RE: **Silver Star Auto Haus**
5111 Wilshire Ave. NE
Grading & Drainage Plan Engineer's Stamp Date: 5/30/2018
Hydrology File: C17D014A1

Based on the information provided in the submittal received on 6/14/2018 the above-referenced Grading and Drainage Plan is approved for Building Permit and SO-19 Permit. Please attach a copy of this approved plan in the construction sets when submitting for a building permit.

EXHIBIT A

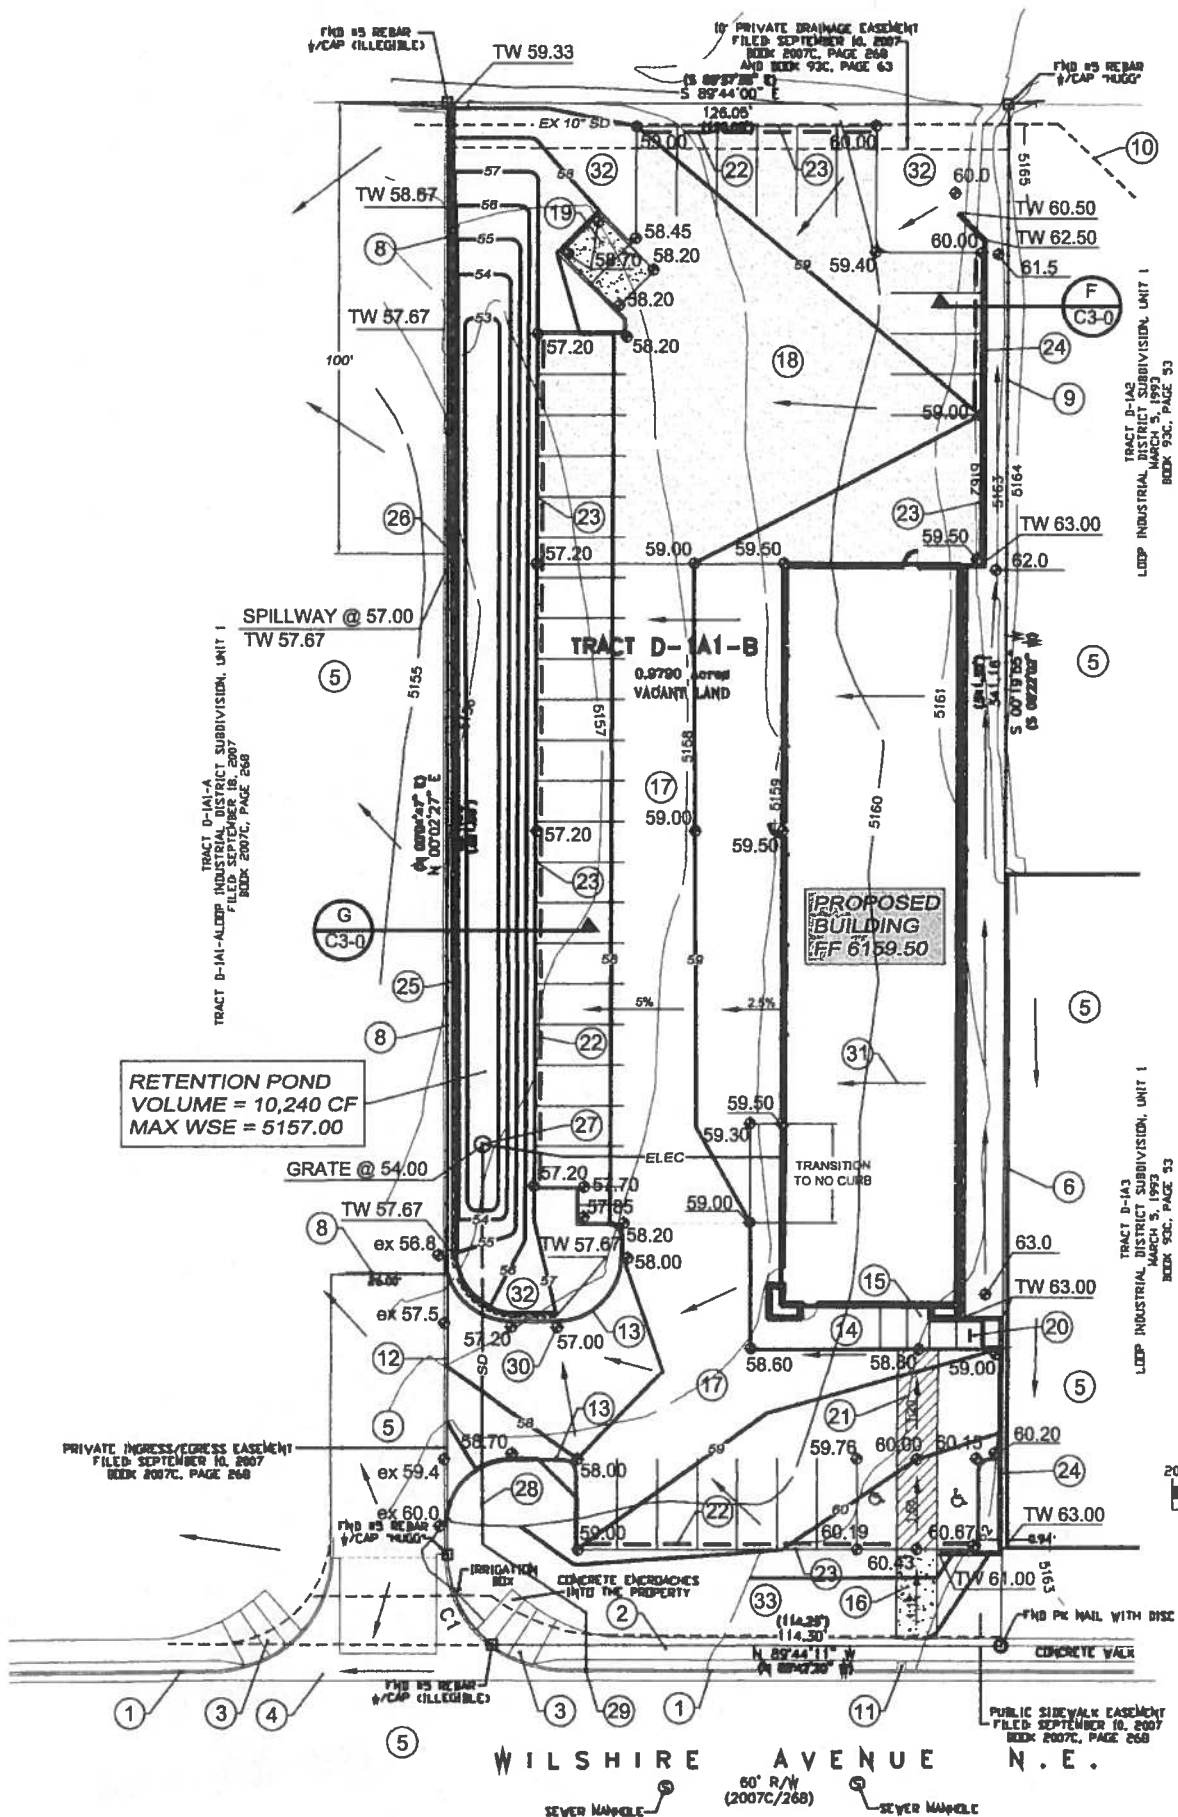
- d. Exhibit 'A' is not legible. It should be at a larger scale and can be on multiple 8.5" x 11" sheets.
